**A38 Derby Junctions**  
**TR010022**  
**8.98 Statements of Common Ground**  
**Position Statement**

**Statements of Common Ground Position Statement**

<b>Regulation Number</b>	Rule 8(1)(k)
<b>Planning Inspectorate Scheme Reference</b>	TR010022
<b>Document Reference</b>	TR010022/APP/8.98
<b>Author</b>	A38 Derby Junctions Project Team and Highways England

CUSTOMER TRACKS

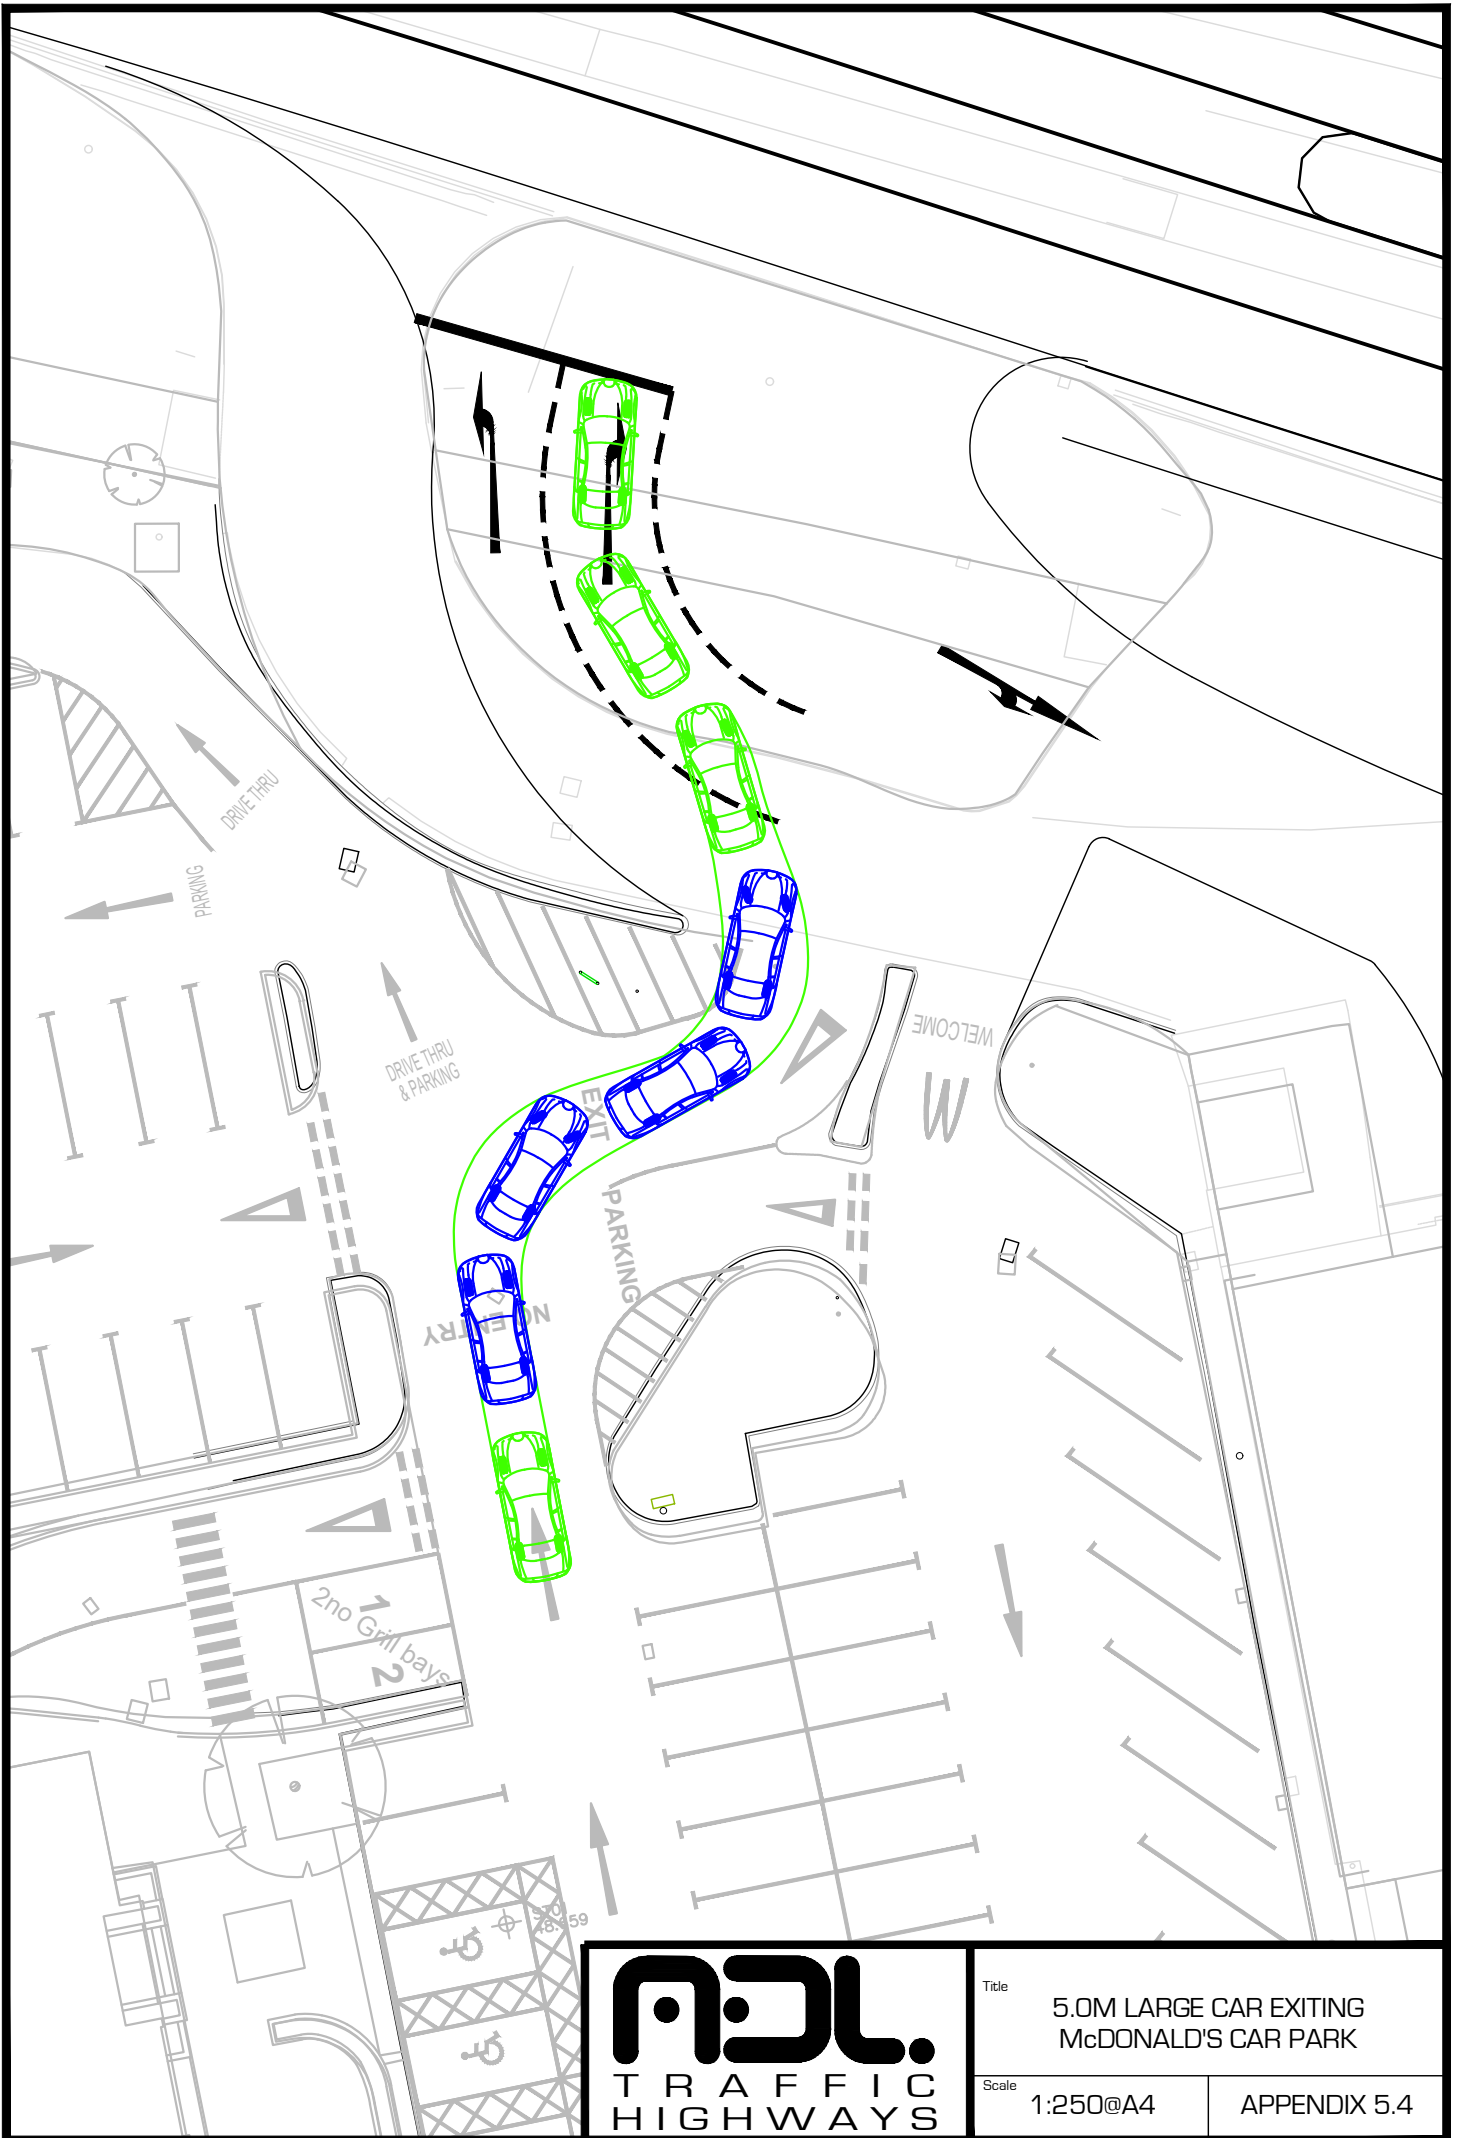
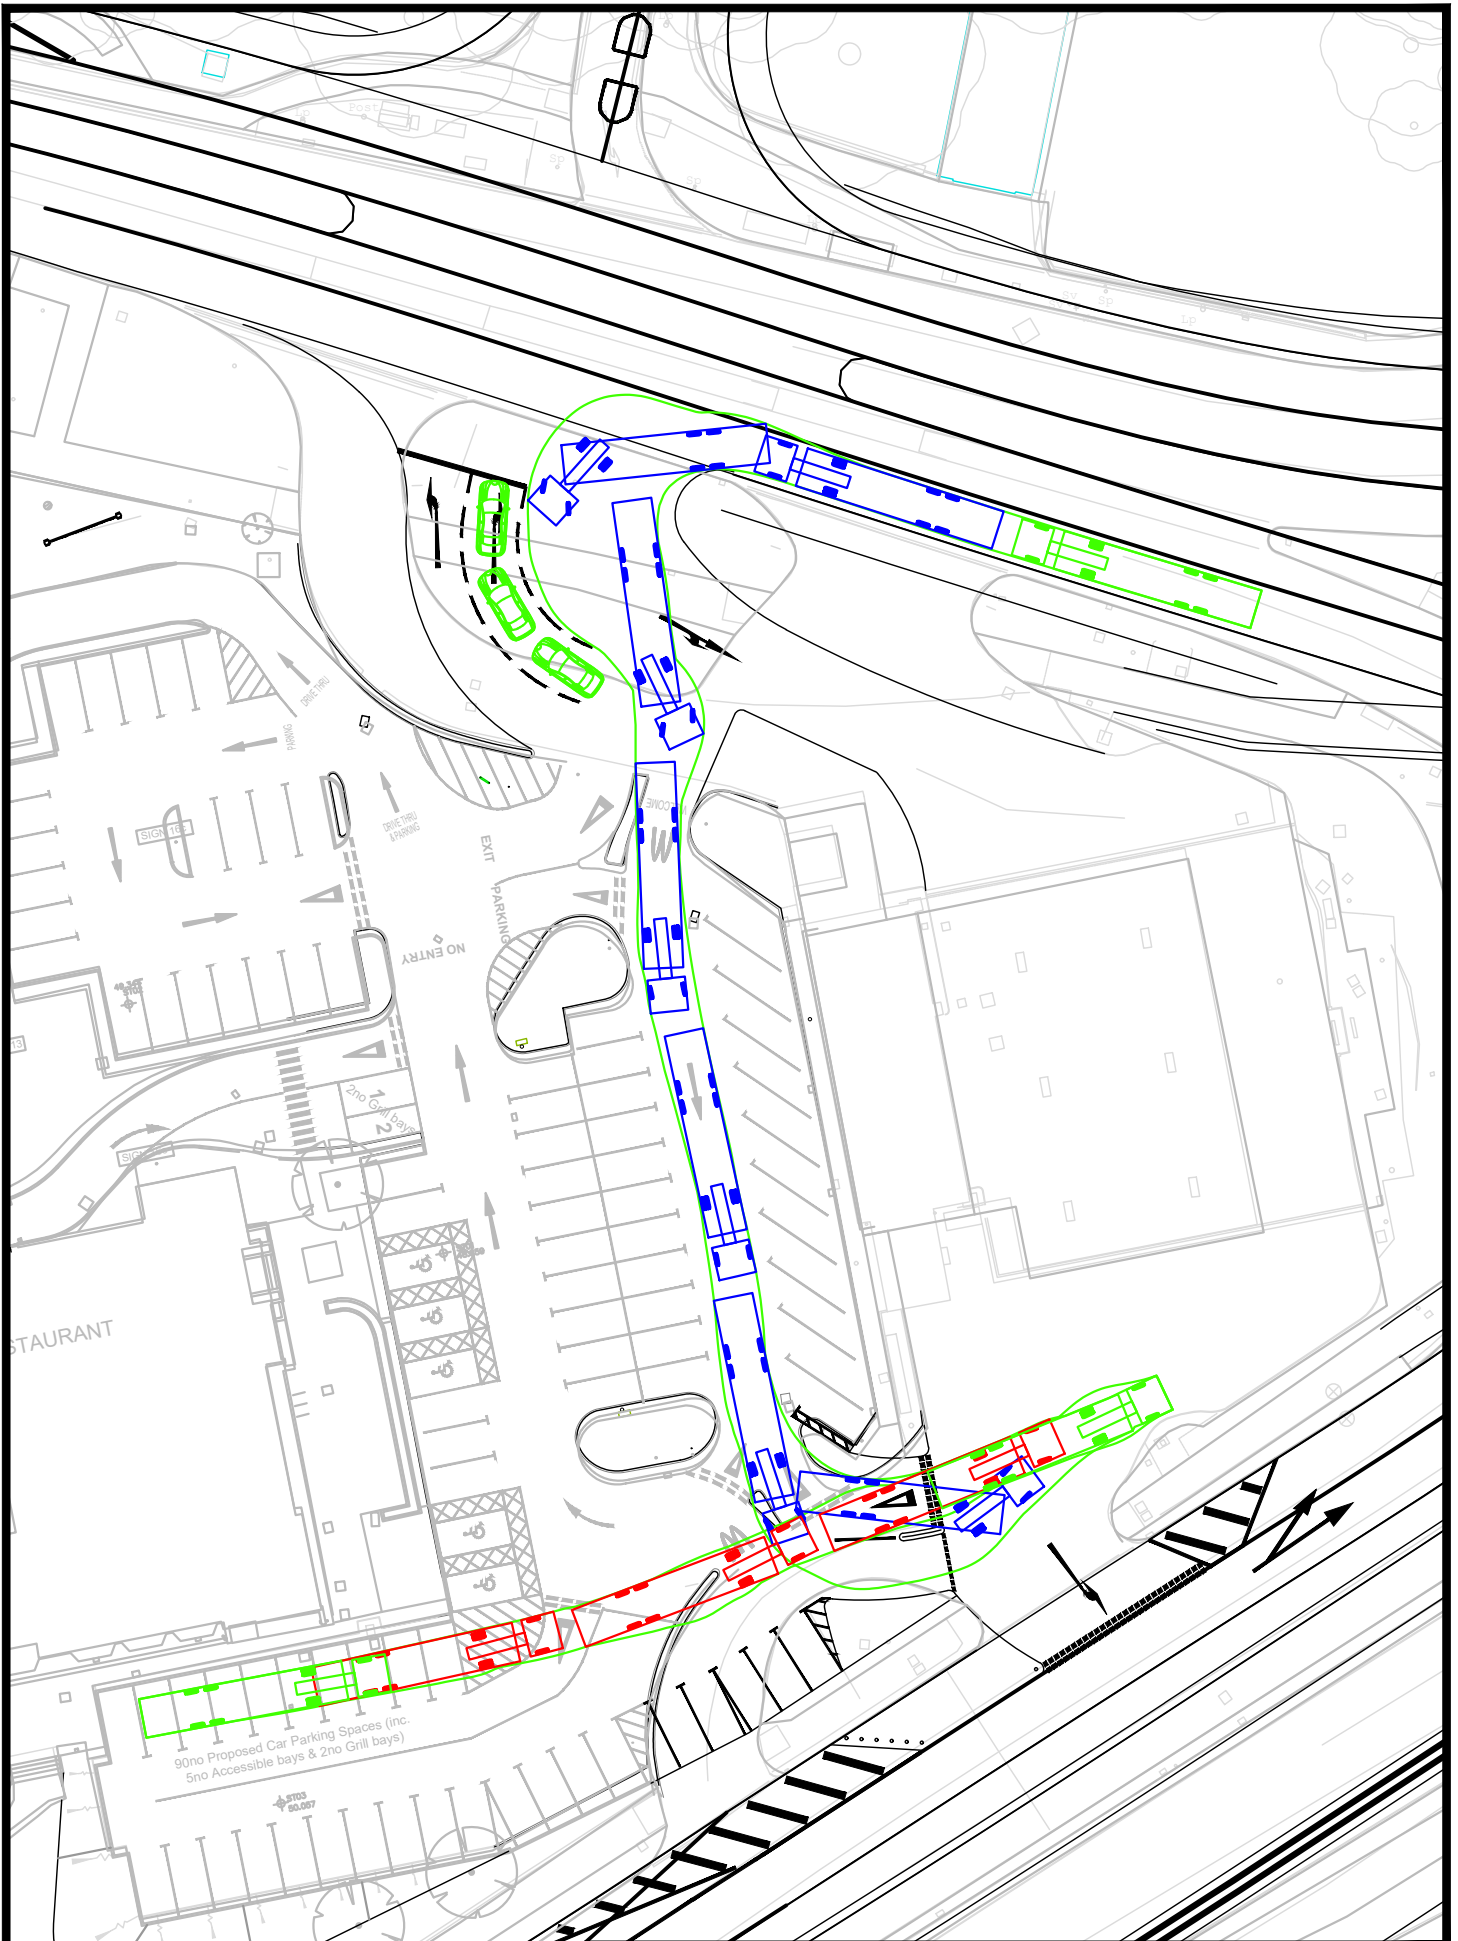
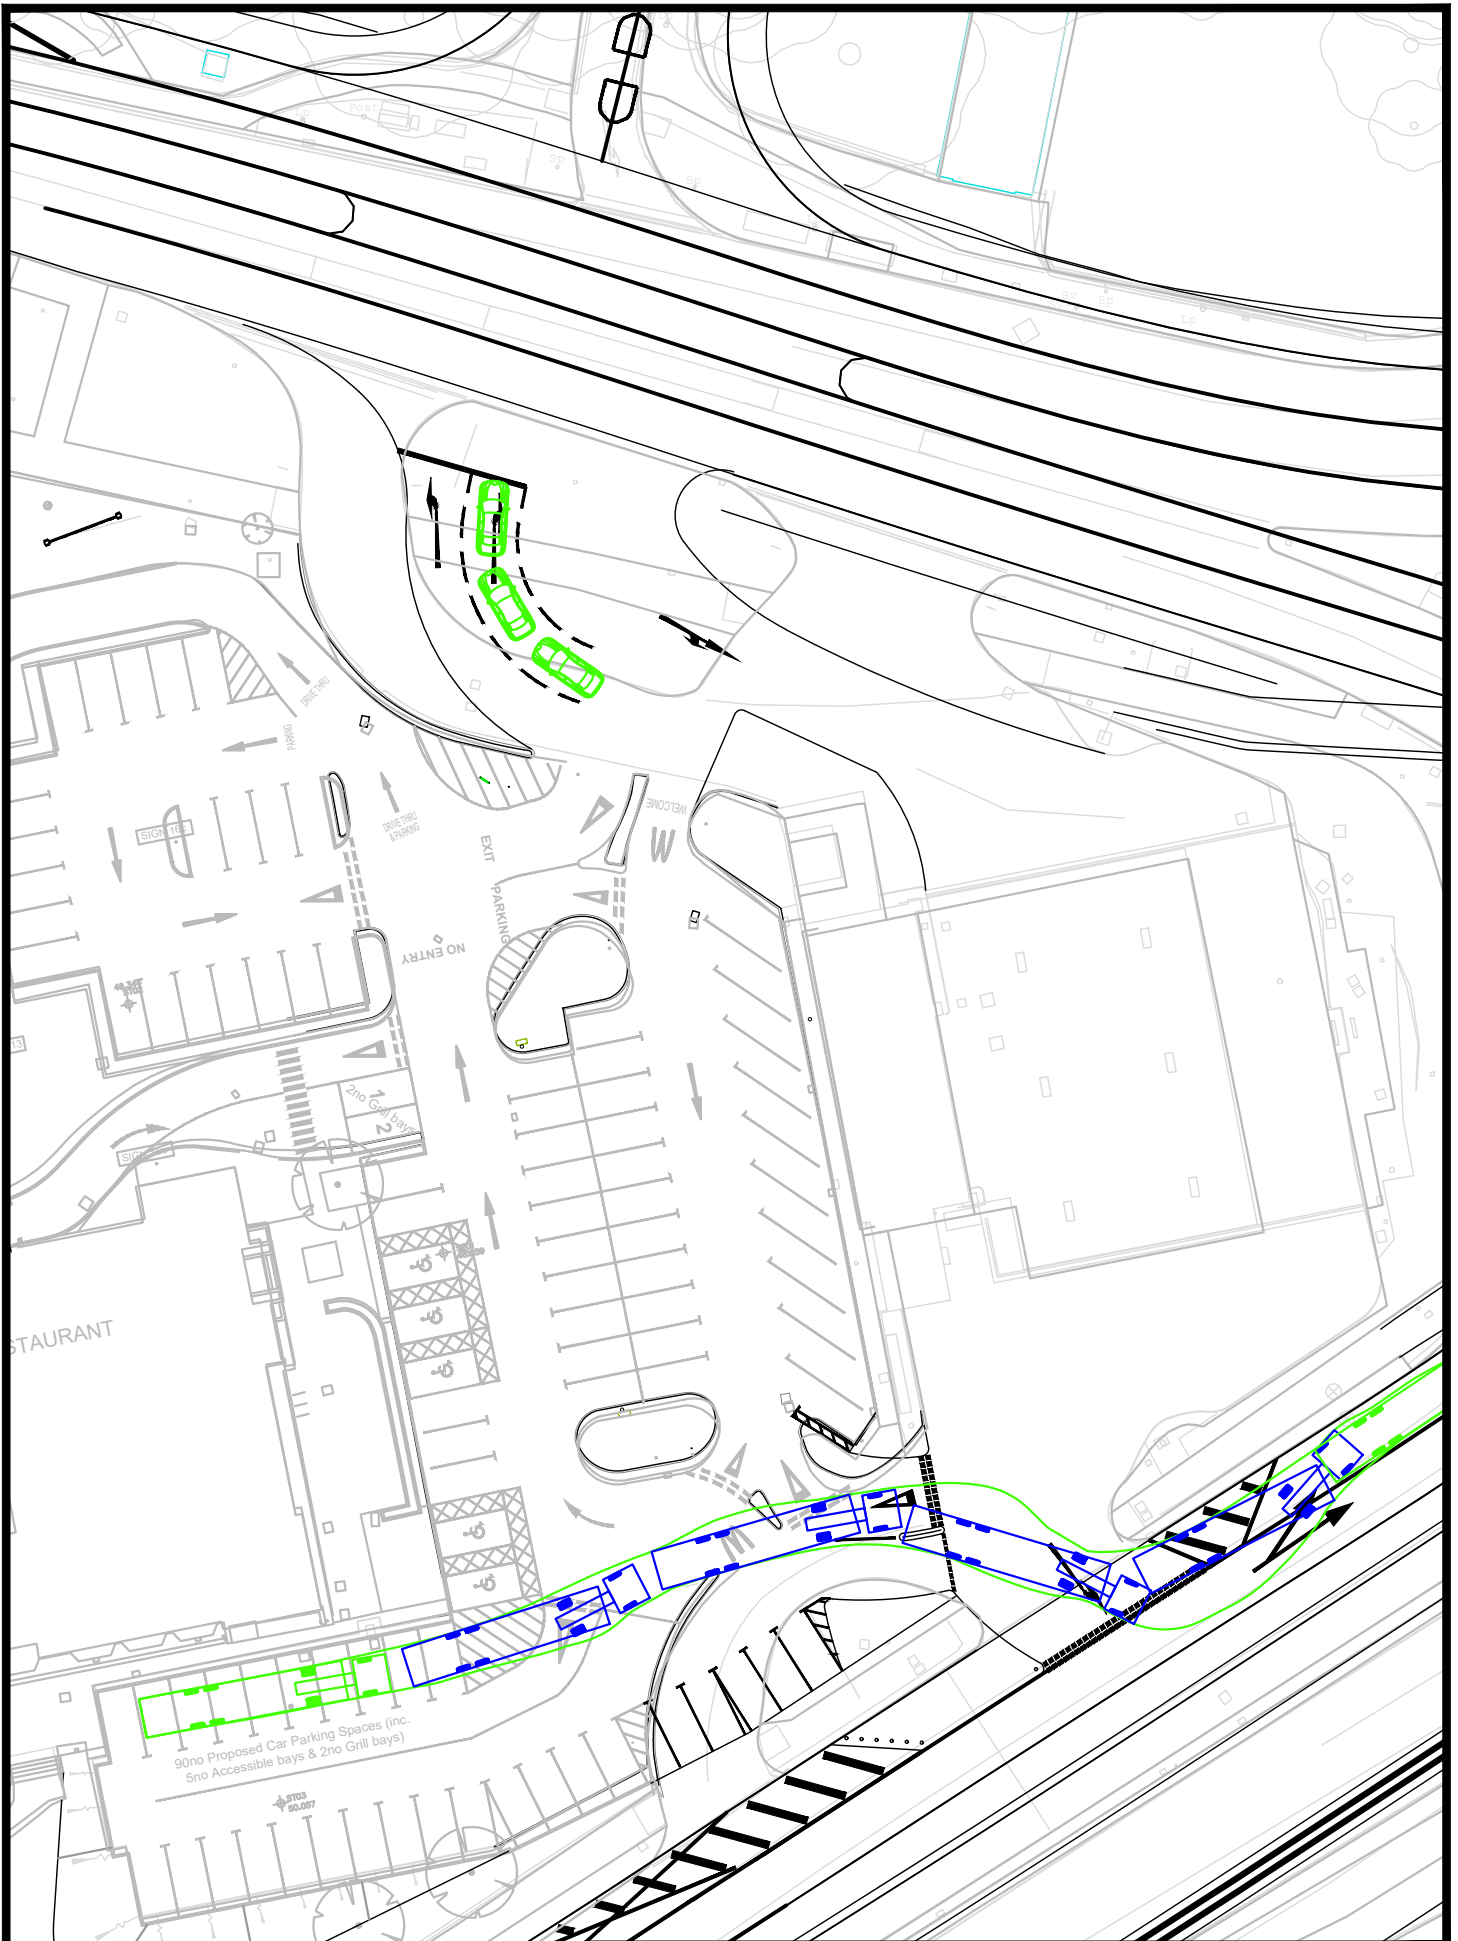
Status	Comment	Applicant's Response and Action
Draft	<p>Currently, deliveries to the Property are received five times per week from the A38 entrance. The Works necessitate a change in delivery routes into the restaurant. The proposed route does not account for how McDonald's delivery vehicles manoeuvre around the Property or potential health and safety concerns. Delivery cages weigh hundreds of kilograms and McDonald's' car park is reinforced in the south part only. By closing the A38 entrance, delivery vehicles will no longer be able to service the Property; they are too heavy to safely cross the unreinforced north section of the Property.</p>	<p>Swept path diagrams have been provided to demonstrate that access for deliveries from the proposed new A52 access is feasible within the current car park layout (and crossing onto the Euro Garages land as they do at present). Highways England has advised that, during the detailed design stage, pavement surveys could be carried out to determine the strength of all parts of the car park with strengthening works carried out as accommodation works if required. Highways England would welcome details of the existing car park construction (strengthened area and non-strengthened area) if available to be able to assess the load bearing capability. At the meeting on the 15th of Jan 2020, McDonald's noted that they have committed to taking core samples in their car park – the resulting information will be shared with Highways England when available. This information has not been provided to date.  <b>ACTION – To be addressed through further joint meeting with McDonalds and Euro Garages during examination phase.</b></p>
